COMPREHENSIVE OBJECTION TO AMENDED STATE SIGNIFICANT DEVELOPMENT APPLICATION

**SSD-83478456 — Residential Development with In-fill Affordable Housing
21, 23 and 25 McIntosh Street and 55 Werona Avenue, Gordon**

Date: 9 June 2026

Submitter: Owner of 12 Forsyth Street, Killara/Gordon (this submission updates earlier submission ref: SUB-92392706).

GENERAL NOTES

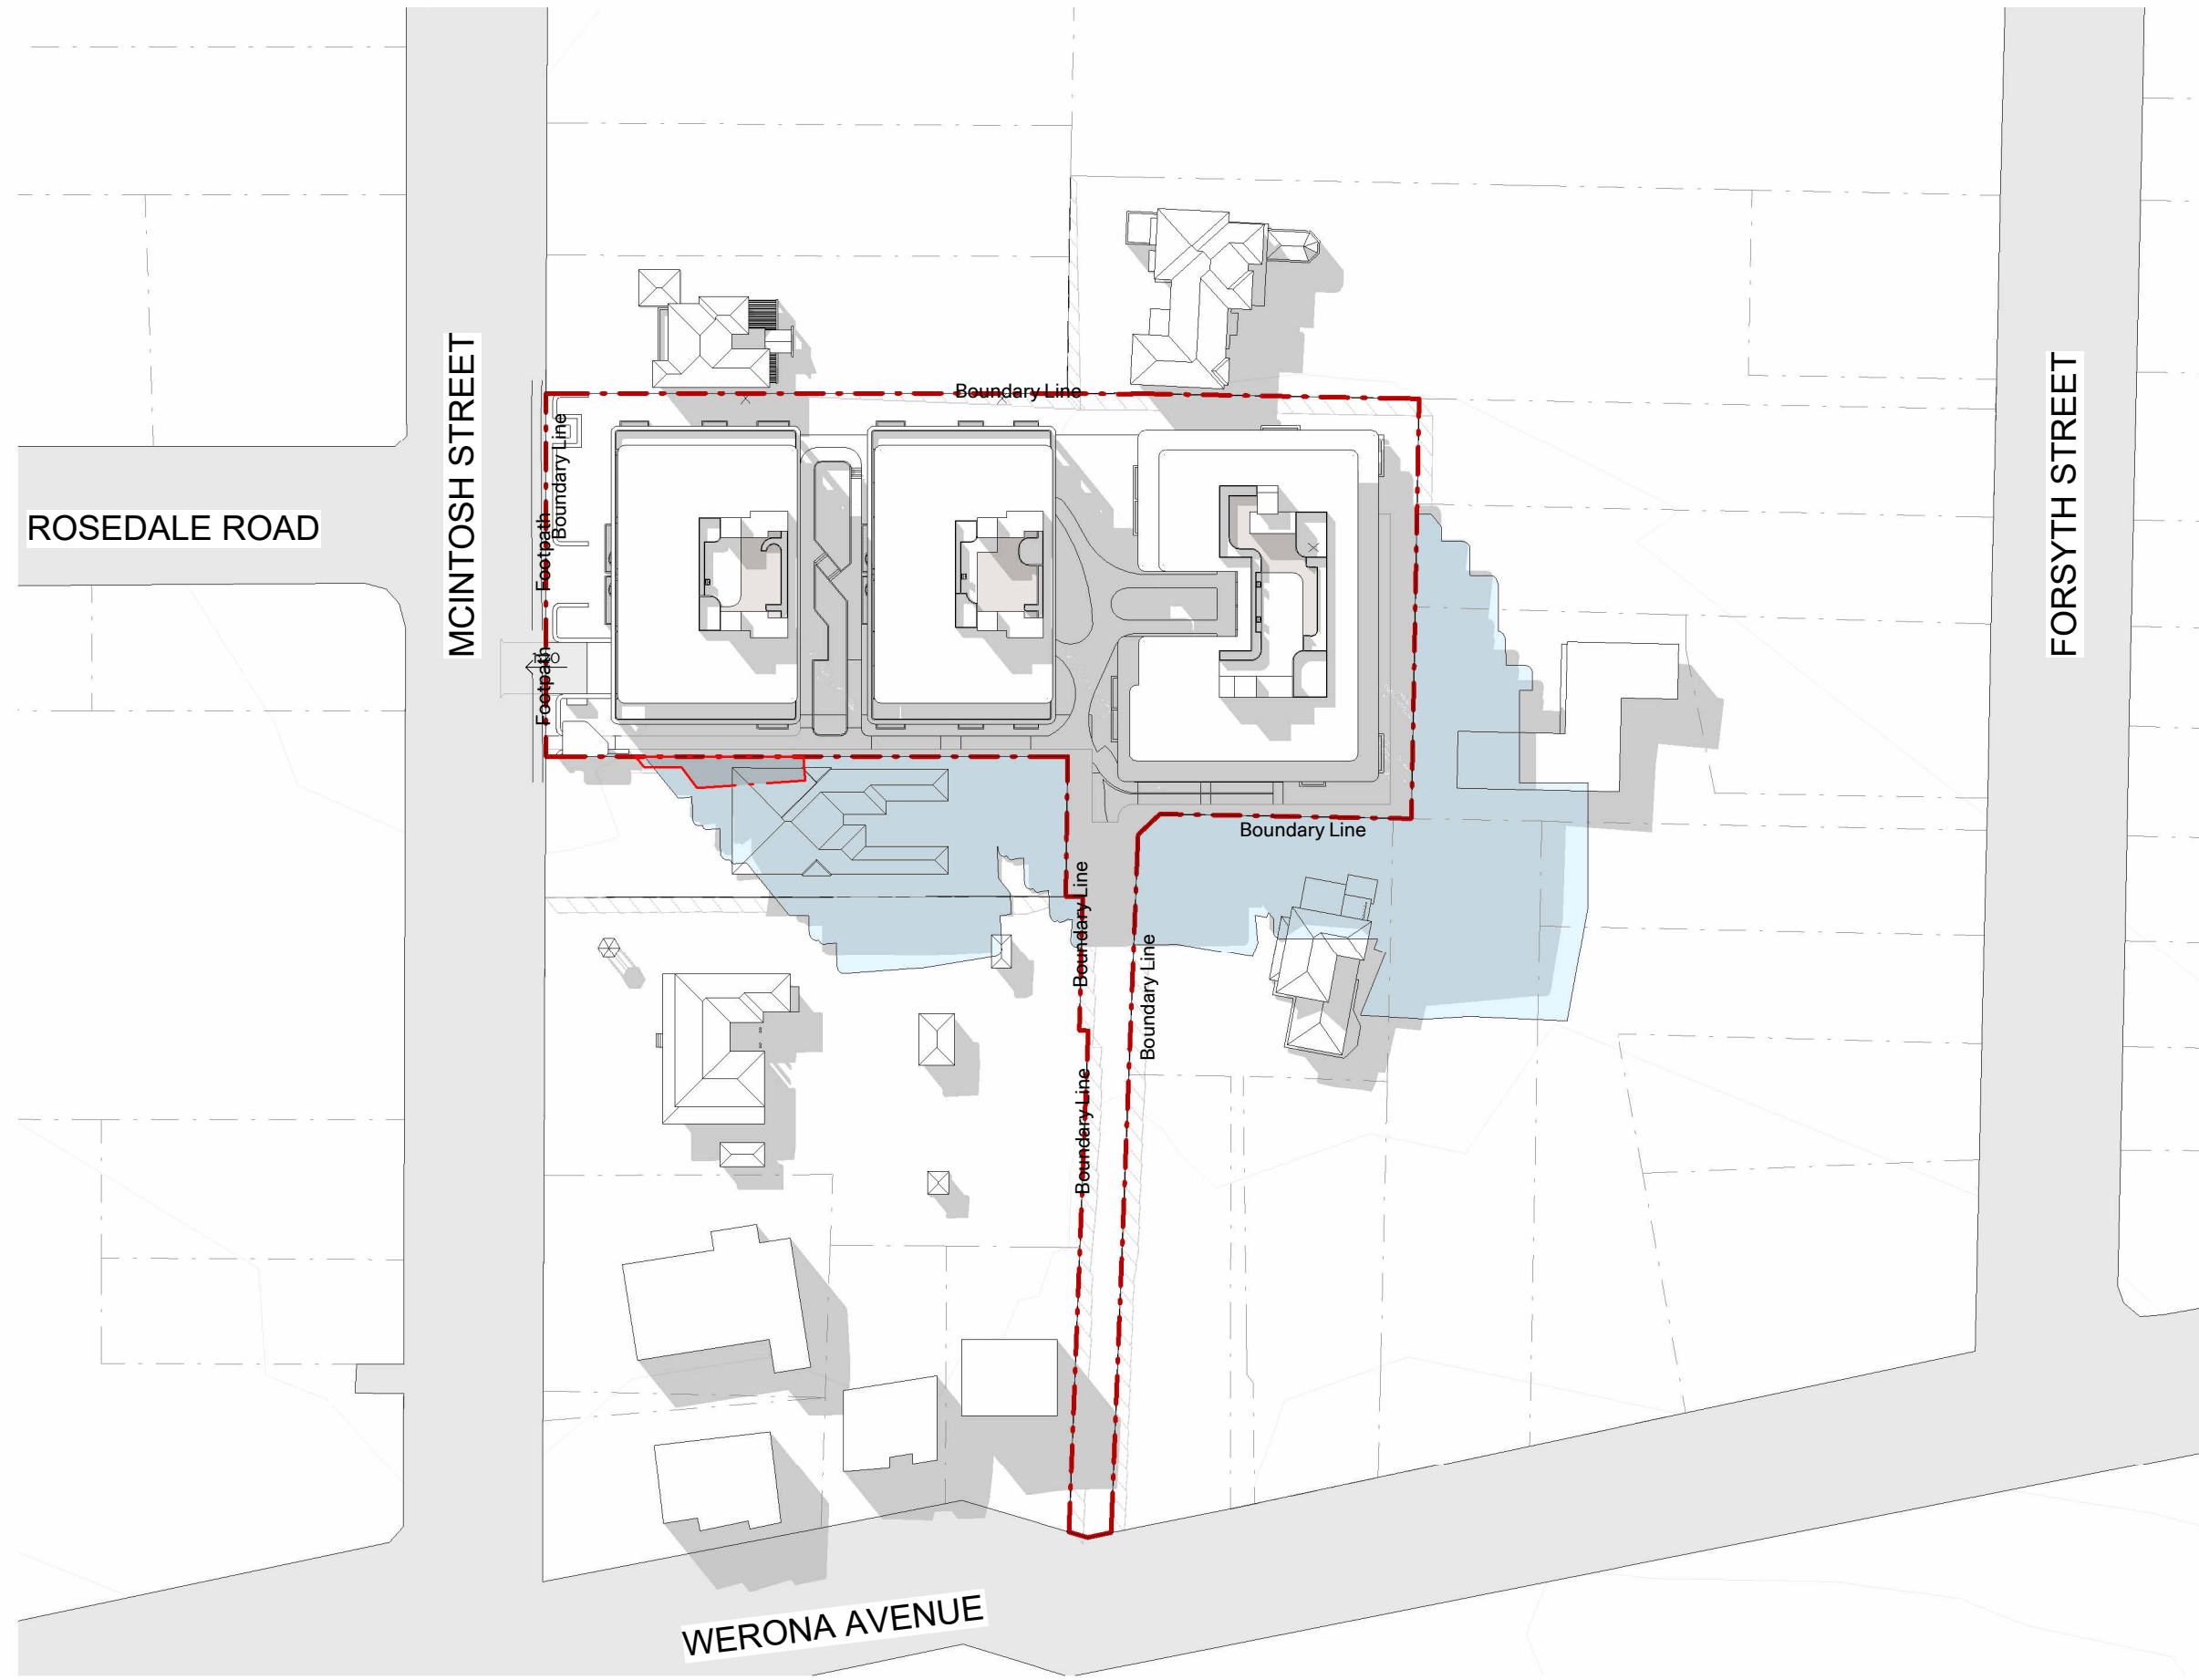
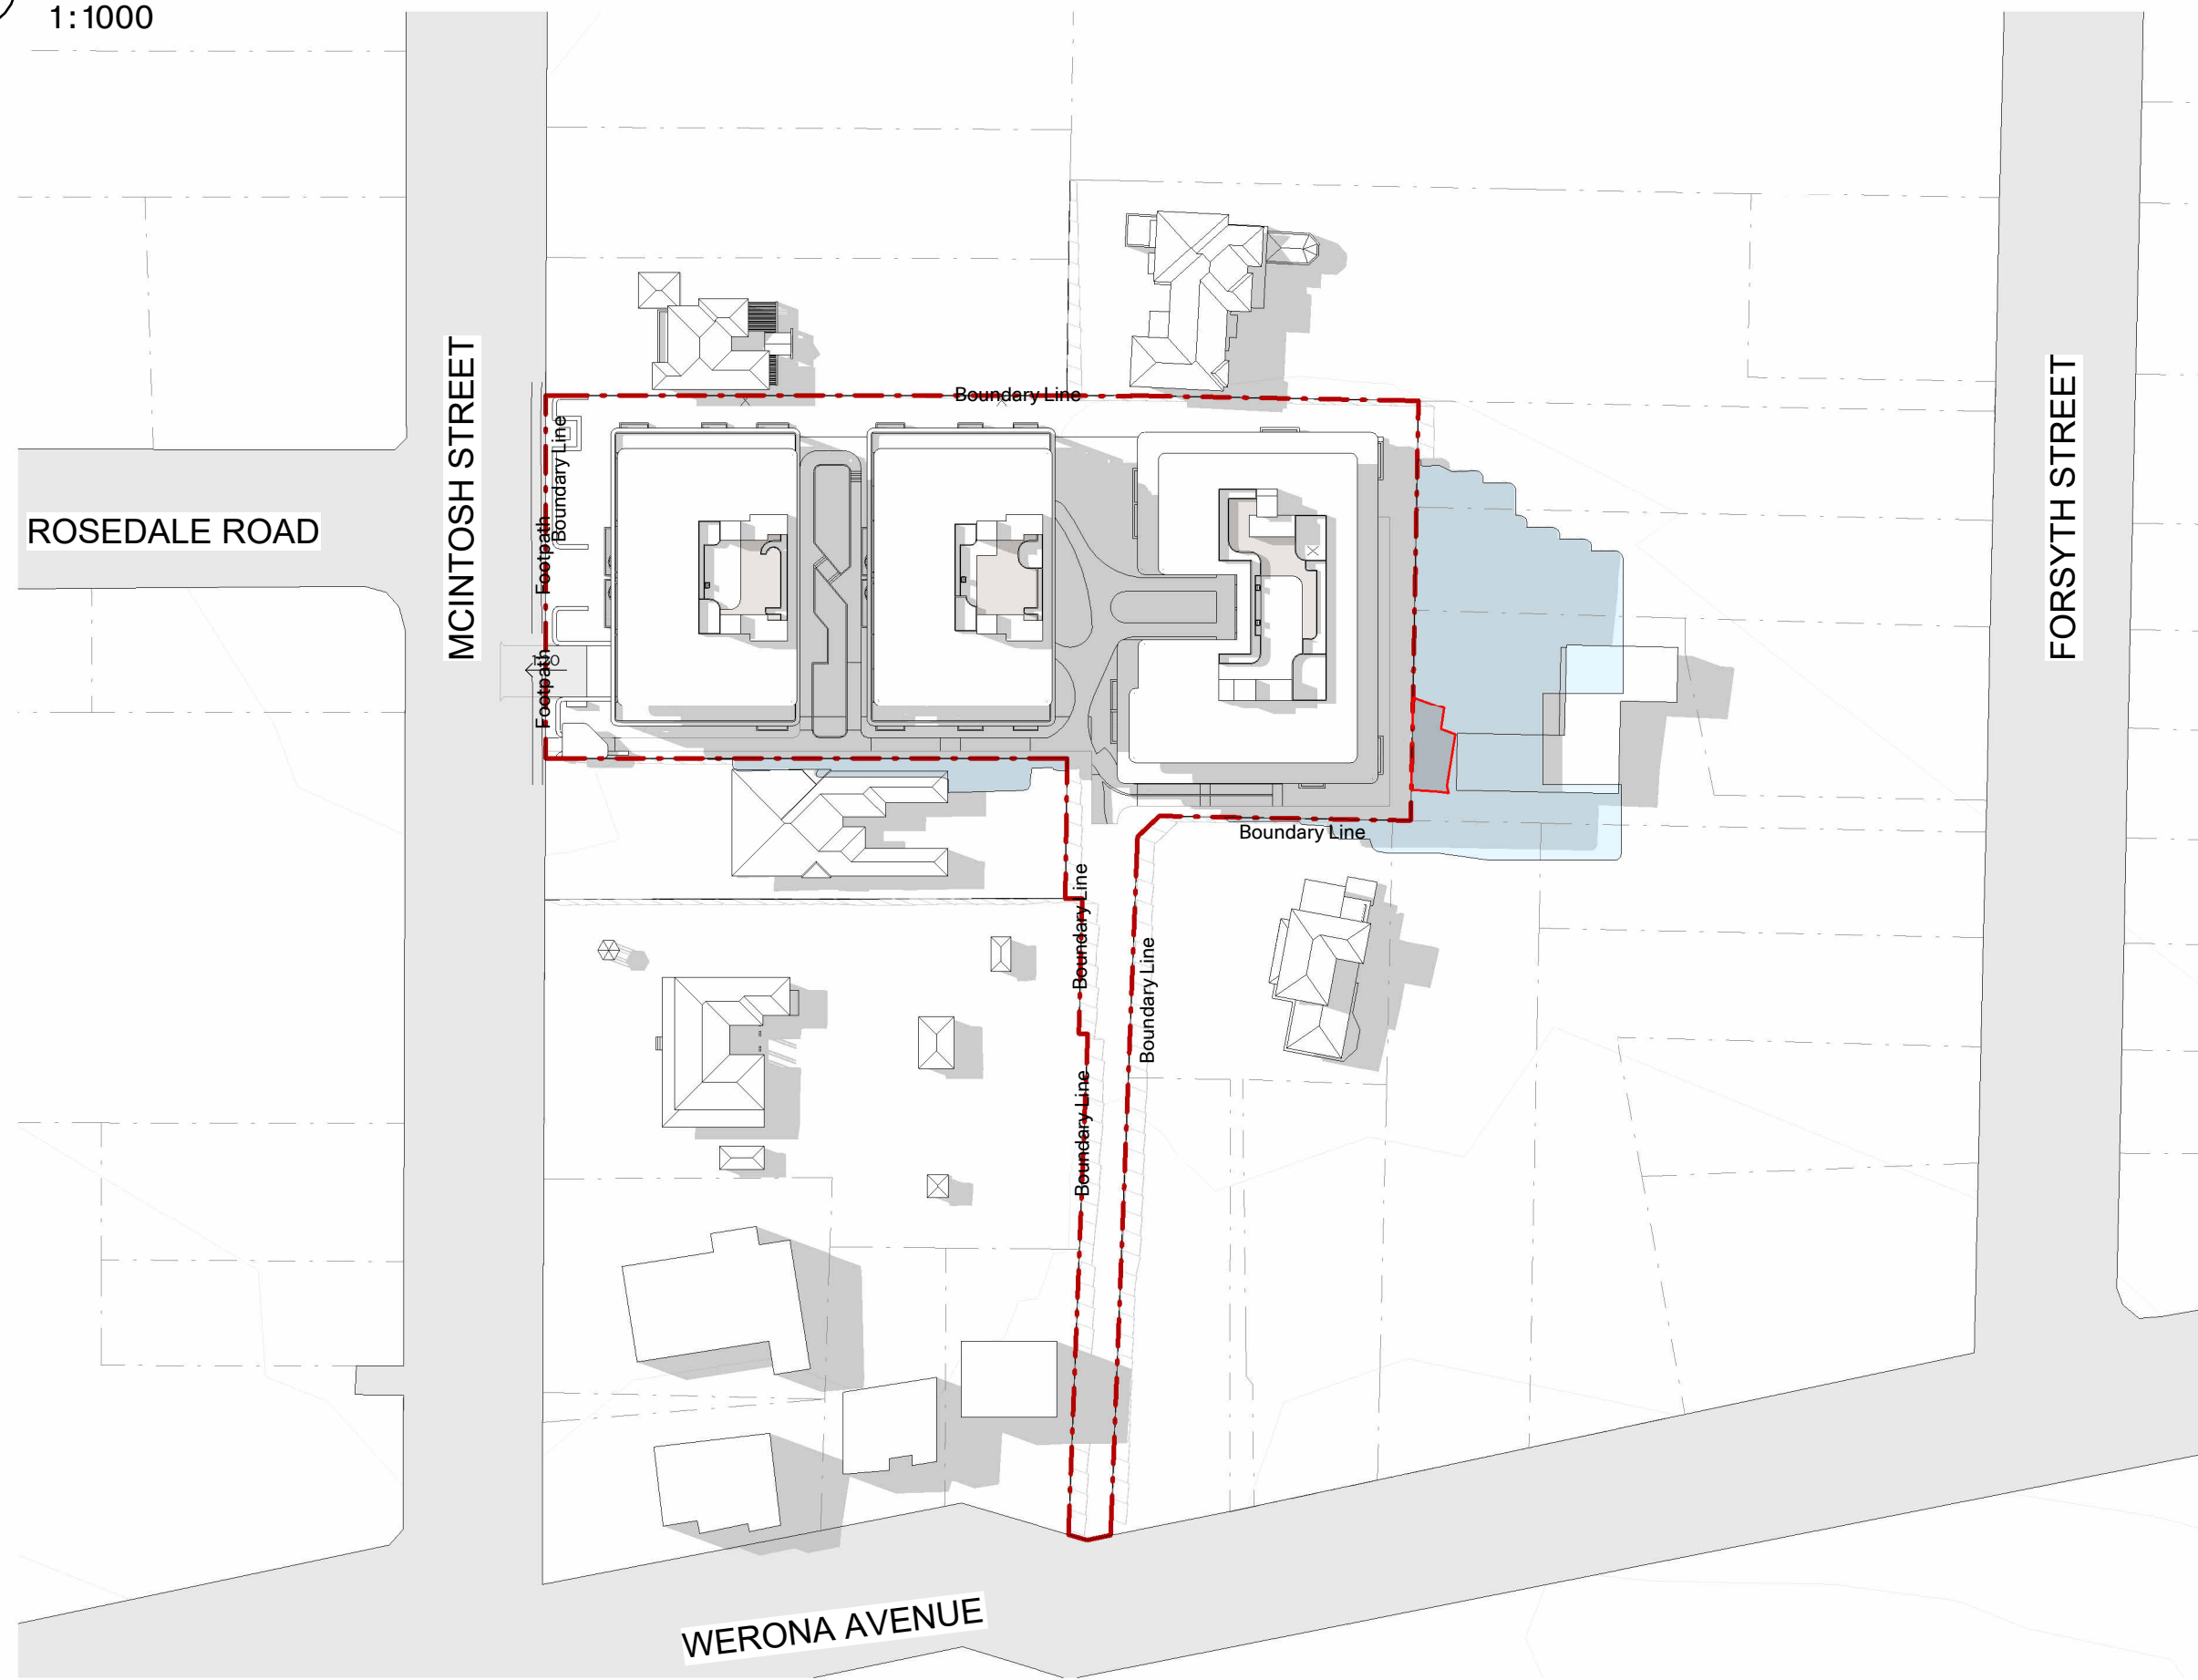
This is the central direct impact on my property. The applicant's own Amendment Report states that 12 Forsyth Street experiences additional overshadowing from the proposed development, that not all parts of the dwelling receive two hours of direct sunlight between 9am and 3pm on 21 June, and that only one primary frontage and a nominated 25 sqm private open space area receive some solar access — while acknowledging this does not fully satisfy the prescriptive controls. The report concedes the proposal does not achieve full compliance with the solar access controls for 12 Forsyth Street in its current form.

This is not a matter of subjective neighbour preference. It is a direct admission that my dwelling is adversely affected. The applicant characterises the impact as “minor” or “partial”; that characterisation should be rejected and the shadow analysis independently verified against my approved two-storey plans. I note the applicant's Stormwater Plans (Appendix P) still describe my property as a “Single Storey Brick Residence Under Construction,” while the architectural plans treat it as two-storey — the shadow and amenity baseline is internally inconsistent and unreliable.

The Department should require the applicant to redesign Building C to remove the non-compliant solar impact — reducing Building C, removing or relocating Level 8 / rooftop communal open space, increasing the southern setback, and providing verified, plan-based shadow diagrams for the actual approved dwelling, living areas, windows and principal private open space at 12 Forsyth Street.
